Claridge Homes Limited
210 Gladstone Avenue
Ottawa, Ontario, K2P 0Y9

October 27th, 2017

RE: 1026 to 1052 Hunt Club Road
Environmental Impact Statement and Tree Conservation Report (Revised) - Addendum #1

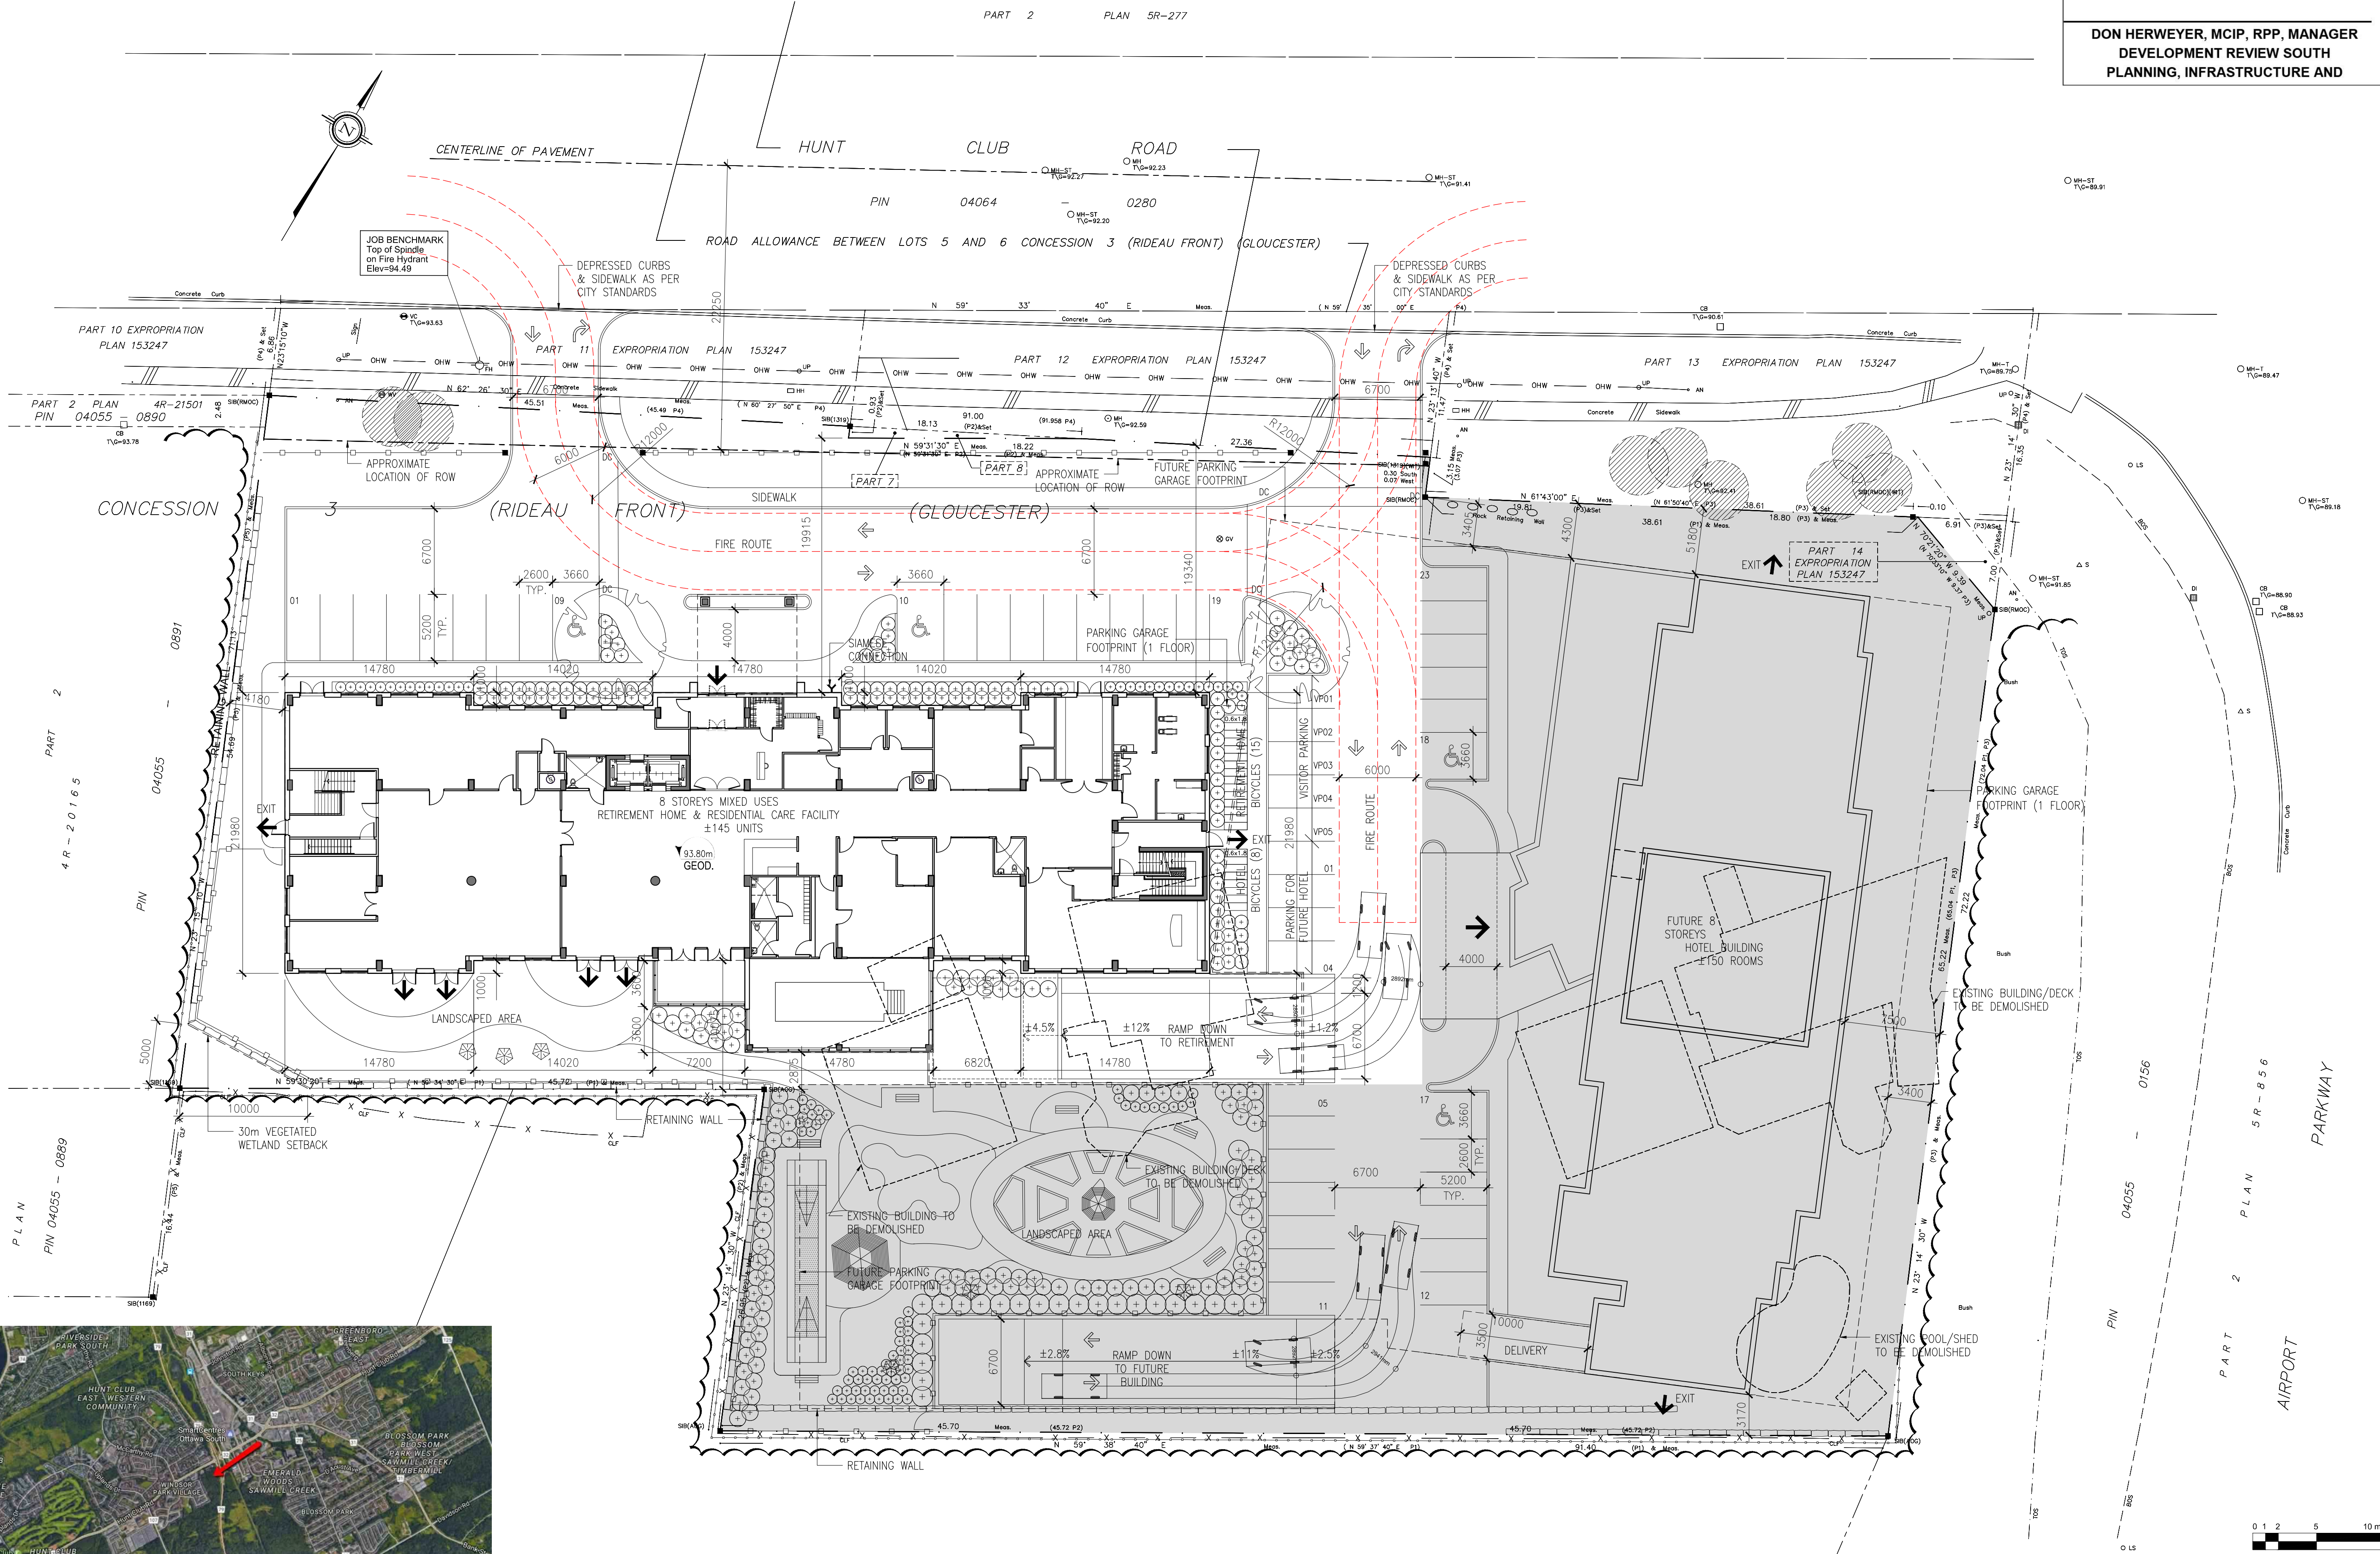
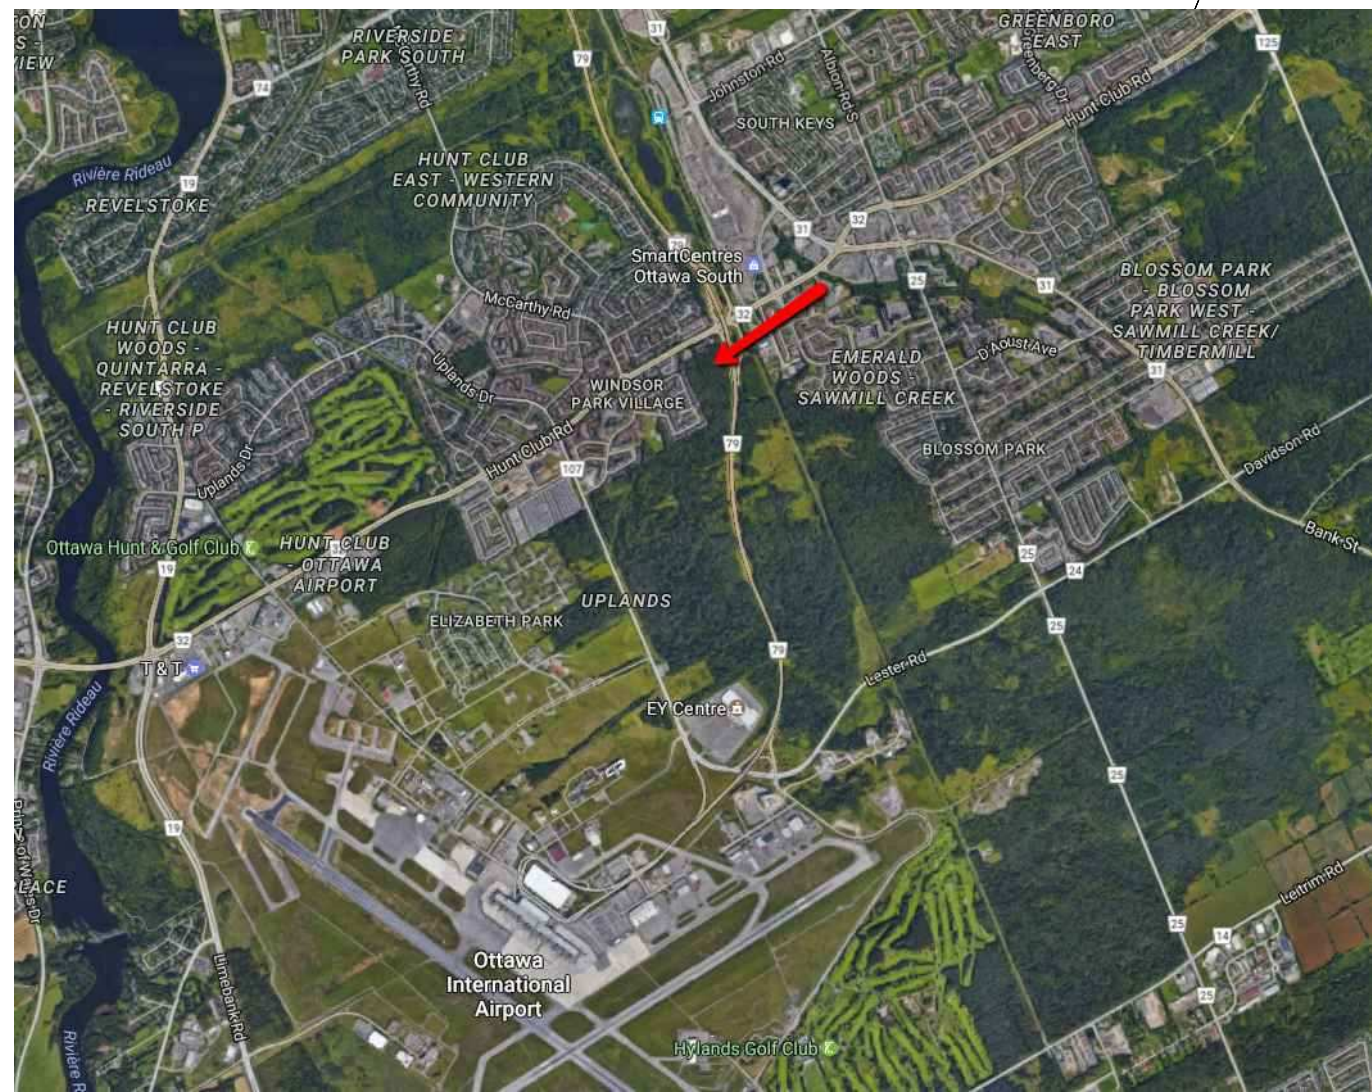
- **Leitrim Road Provincially Significant Wetland (LRPSW) Setback:** The RVCA stated that the reduced setback of 27 m in the southwest corner of the Site was not sufficient. It was requested that the wetland setback be re-evaluated;

As shown in Figure 1, the distance between the LRPSW and the property line varies between approximately 27 m and 115 m. The distance between the wetland edge and the property line is narrowest (27 m) in the southwest corner of 1026 Hunt Club Road. In the EIS and TCR, it was previously proposed that a retaining wall and fence would be constructed along the property line. This would have placed the retaining wall 27 m from the wetland edge in the southwest corner of 1026 Hunt Club Road, thereby providing 27 m of forest between the wetland edge and the limit of development. It was also proposed that the 27 m setback from the wetland edge would be supplemented with a 10 m wide landscaped area, which would have been included on the development side of the retaining wall, within the southwest corner of 1026 Hunt Club Road. The RVCA stated that this arrangement was not sufficient to provide an adequate wetland setback.

In response to RVCA comments, the Site Plan (above) has been adjusted so that the retaining wall, fence, and all other infrastructure/development activities will be oriented to provide a minimum 30 m setback from the wetland edge throughout the Site. As shown in Figure 3 (below), the minimum 30 m setback from the wetland edge overlaps the southwest corner of 1026 Hunt Club Road. The area where the minimum 30 m setback overlaps the Site is approximately triangular in shape and measures approximately 5 m x 10 m (measured along the property line). The Site Plan has been adjusted to move the retaining wall, fence, and all other development activities outside of the 5 m x 10 m triangle in the southwest corner of 1026 Hunt Club Road, thereby providing a minimum 30 m setback from the wetland edge. The 5 m x 10 m triangle is currently developed and includes an area of compacted gravel. During development, the compacted gravel will be removed and trees will be planted to reforest the 5 m x 10 m triangle. Reforestation of the 5 m x 10 m triangle increases the total extent of tree planting that will be undertaken as part of the development, while also restoring the functionality of the minimum 30 m wetland setback, where it overlaps the Site. The Landscaping Plan has been adjusted to show additional tree planting within the 5 m x 10 m triangle in the southwest corner of 1026 Hunt Club Road.

With the adjusted wetland setback implemented, the Site Plan now provides a forested wetland setback that varies between approximately 30 m and 115 m throughout the Site. The 30 m to 115 m wide vegetated wetland setback will help to slow, filter and absorb overland stormwater flow, it will provide habitat for wildlife, and it will also provide a buffer from edge effects, noise, pollution, and other forms of human disturbance. The adjusted wetland setback achieves a minimum of 30 m setback across the Site, and hence is anticipated to be sufficient to protect the features and functions of the LRPSW.
